13 December 2019
Document Ref: NCA19R104676

Subject: Warnervale Public School - Submissions from Central Coast Council (Council) and the Biodiversity Conservation Division (BCD)

Kleinfelder was engaged by Billard Leece Partnership, on behalf of the NSW Department of Education, to undertake a Biodiversity Development Assessment Report (BDAR) within Lot 71 DP 7091 Warnervale Road, Warnervale, NSW. This BDAR was prepared to assess the impacts of the proposed New Primary School at Warnervale, and future expansion options. Following review of the BDAR by Central Coast Council (Council) and the Biodiversity Conservation Division (BCD) of the Department of Planning, Industry and Environment (DPIE), submission comments on the findings of the BDAR were provided. Additionally, Kleinfelder met with Council on 02/12/2019 to discuss the project.

Figure 10 | Location of Squirrel Glider connectivity corridor (Source: Applicant's SRtS)

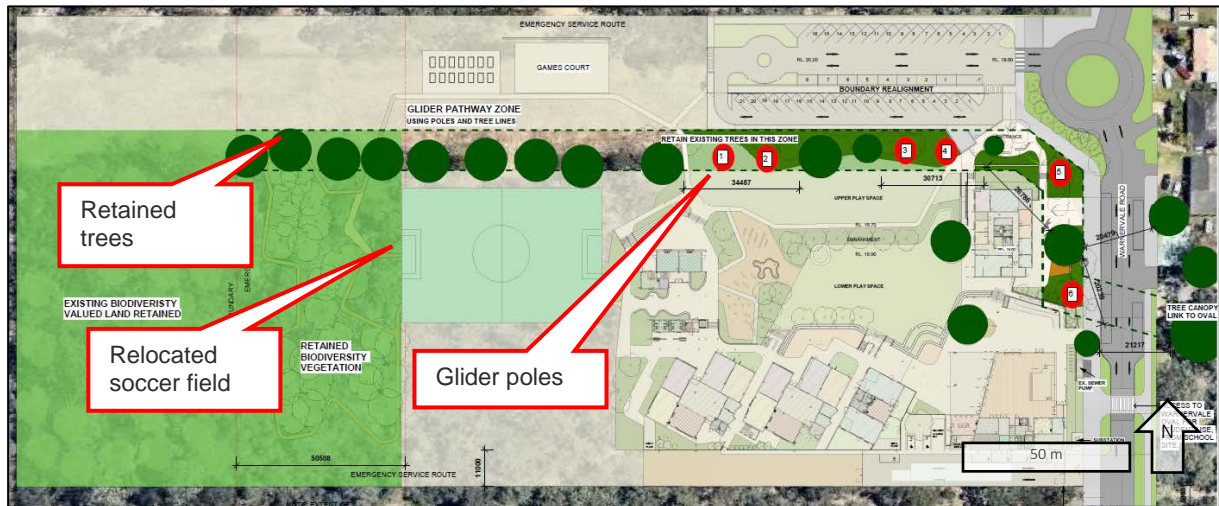
4	Council	<p>A north-south tree canopy corridor (preferably eastern side) is to be provided through the site to link with the vegetation and oval on the northern side of Warnervale Road. The corridor is to include native trees whose canopy provides a linkage for fauna through the site to Warnervale Road and should</p>	<p>A strategy for the site design has been developed to improve connectivity based on the retention of trees and the installation of glider poles. This has been provided to ensure that canopy linkages are maintained within the site to allow movement and dispersal of Squirrel Gliders from north to south. A figure showing the preliminary design of this strategy is presented in Appendix A.</p> <p>The <i>Lake Macquarie Squirrel Glider Management Guidelines (2015)</i> state that Squirrel Gliders can glide for approximately 1.8 times the launch height (less 2 m, assuming landing 2 m off the ground). Further investigations will be required to effectively position glider poles within the site; however, for the purposes of preparing a preliminary design, the average tree height within the site is estimated to be approximately 12 m. The locations of Glider poles have therefore been selected to ensure that the</p>

Item	Submission	Comment	Response
		include replacement street tree planting with a large canopy to allow for a squirrel glider link between the tree canopies and vegetation located on either side of Warnervale Road. This corridor currently exists on site and needs to be retained to minimise potential for the existing squirrel glider population to be adversely impacted by the proposal.	resultant gaps are no greater than 18 m. Taller trees, or installation of a minimum 14 m pole along the road frontage will allow for appropriate glide distance across Warnervale Road. Additional considerations may be required for the connectivity strategy such as ensuring that Gliders do not glide through areas where injury may occur, such as in areas containing powerlines, roads or other infrastructure.
5	Council	The subject site provides the best location for provision of this corridor in comparison to adjoining lots. Council is currently developing a Squirrel Glider monitoring program that will include survey of that vegetation surrounding Warnervale Oval.	This comment has been addressed previously for <i>Item 4</i> which discussed the strategy to improve habitat connectivity for the Squirrel Glider.

CONCEPT | LANDSCAPE MASTERPLAN

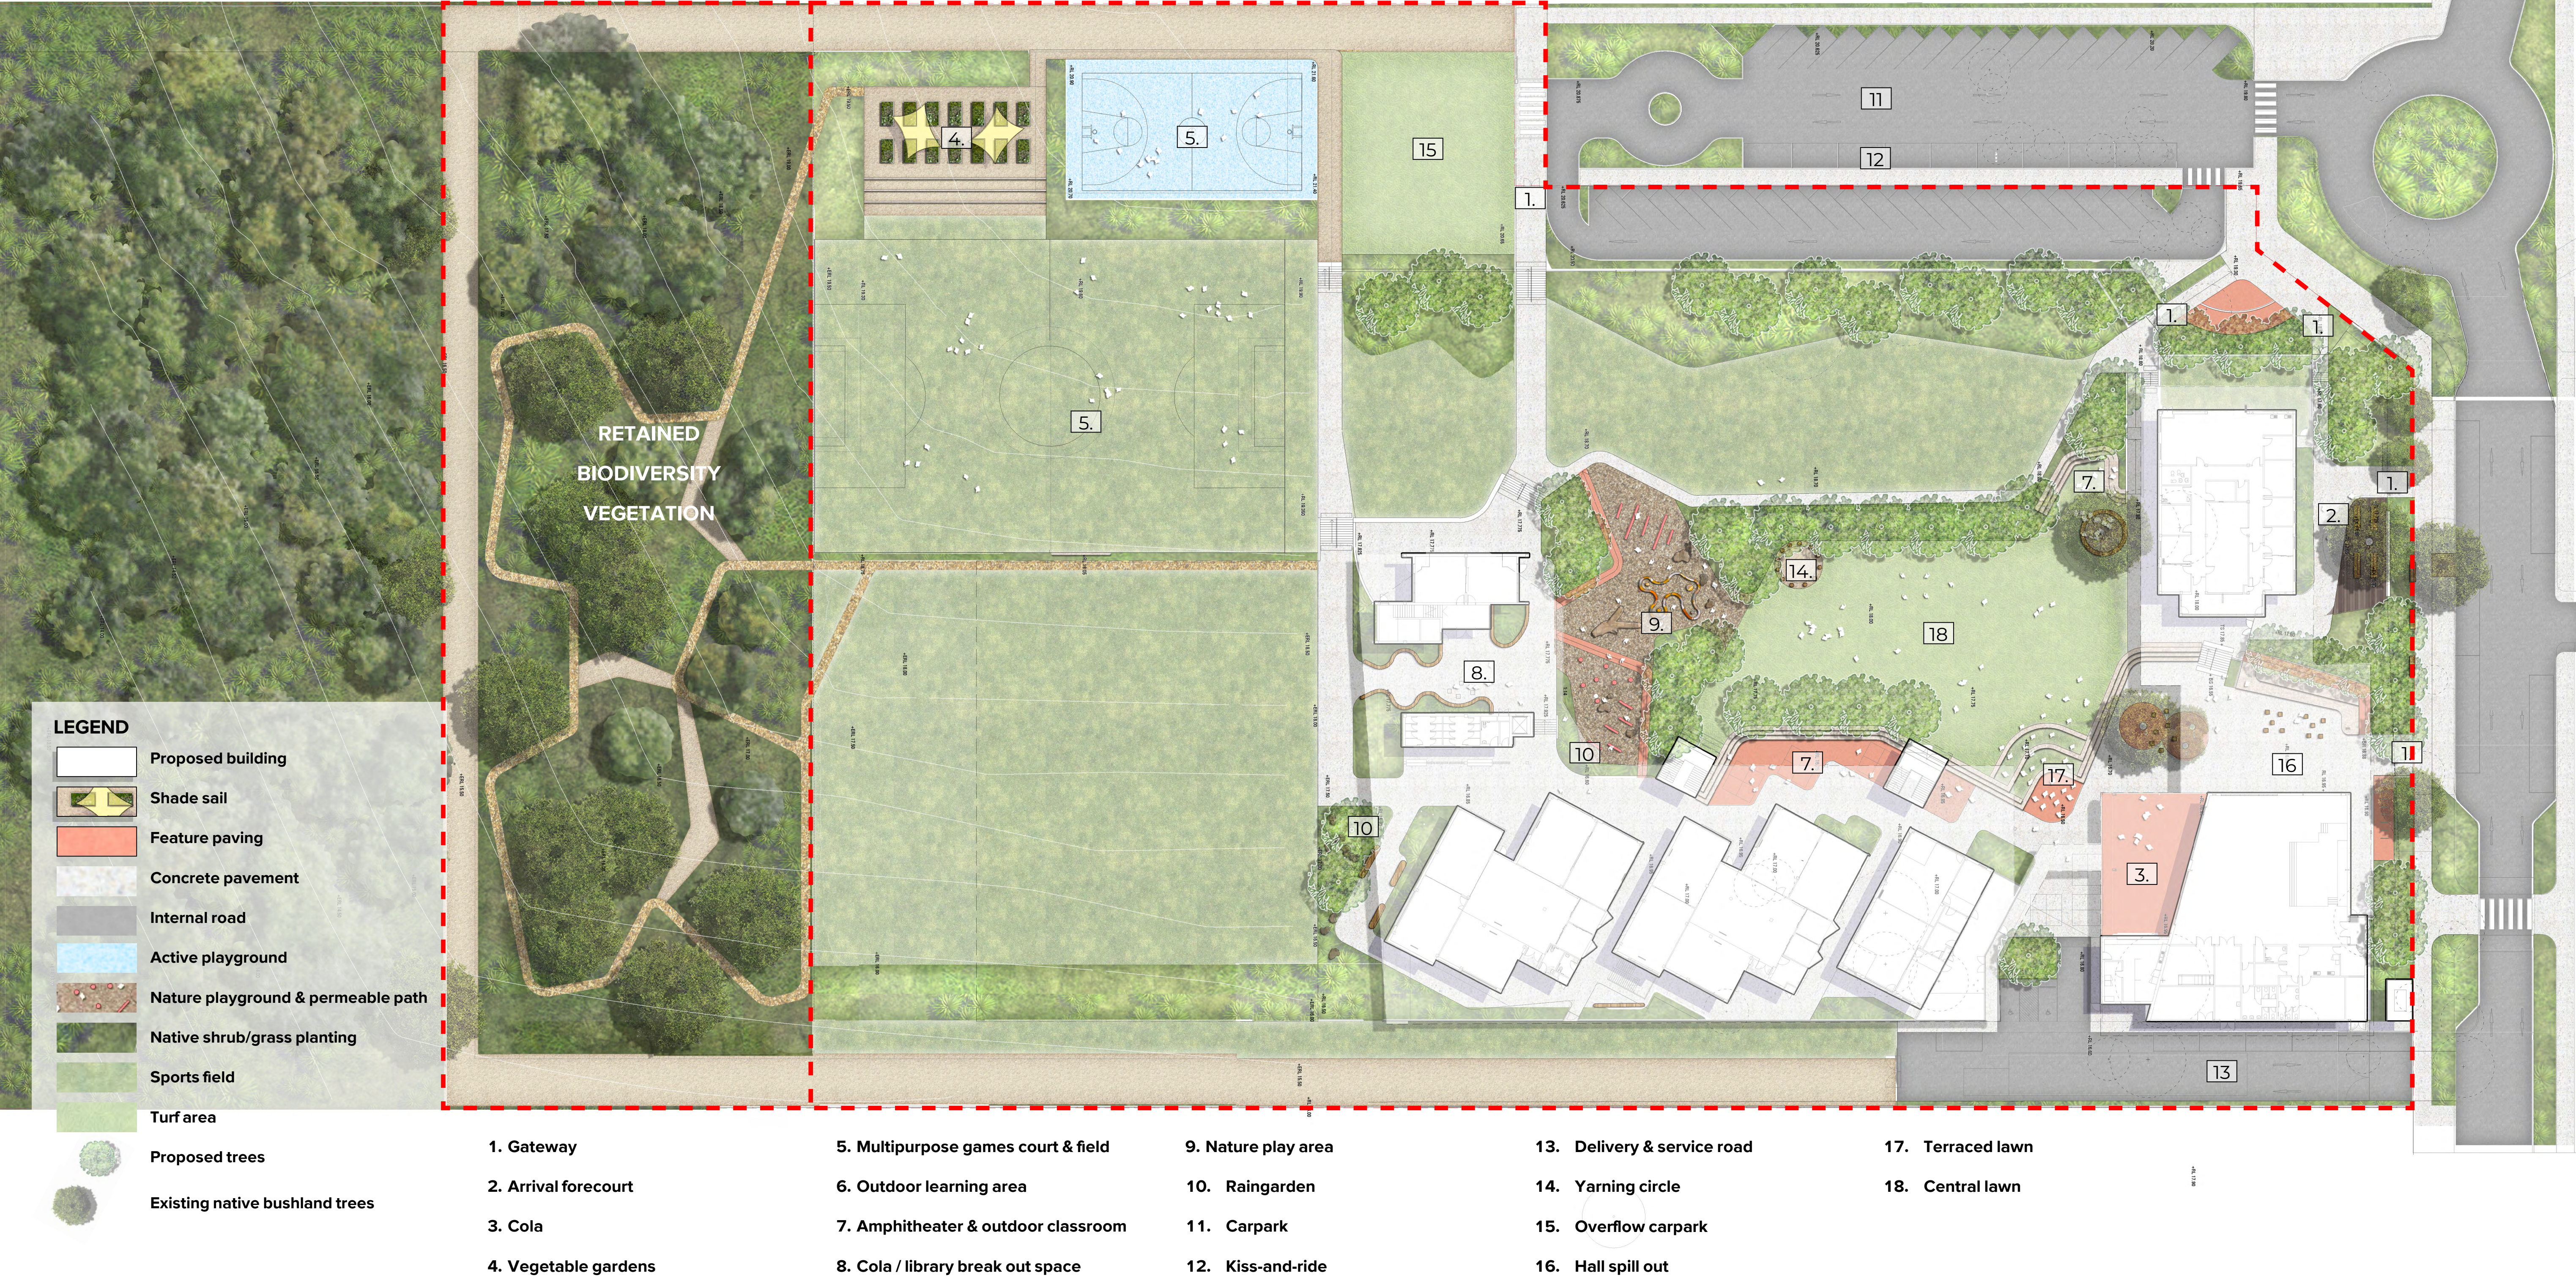
8		<p>Concern is raised regarding the extent of tree removal associated with the proposal. Replacement native tree planting to compensate for the loss of trees along the street front, within the street setback and areas adjacent to the side boundary (within proximity and view of the street) should be investigated and carried out.</p>	<p>The VMP includes recommendations for a revegetation program to compensate for street front, within the street setback and areas adjacent to the site boundary</p>
9		<p>The street trees also provide for a linking corridor of vegetation across Warnervale Road which is being impacted under the proposal. The squirrel glider glides between trees and the species is sensitive to habitat fragmentation when tree gaps exceed its gliding ability.</p>	<p>This comment has been addressed previously for <i>Item 4</i> which discussed the strategy to improve habitat connectivity for the Squirrel Glider.</p>
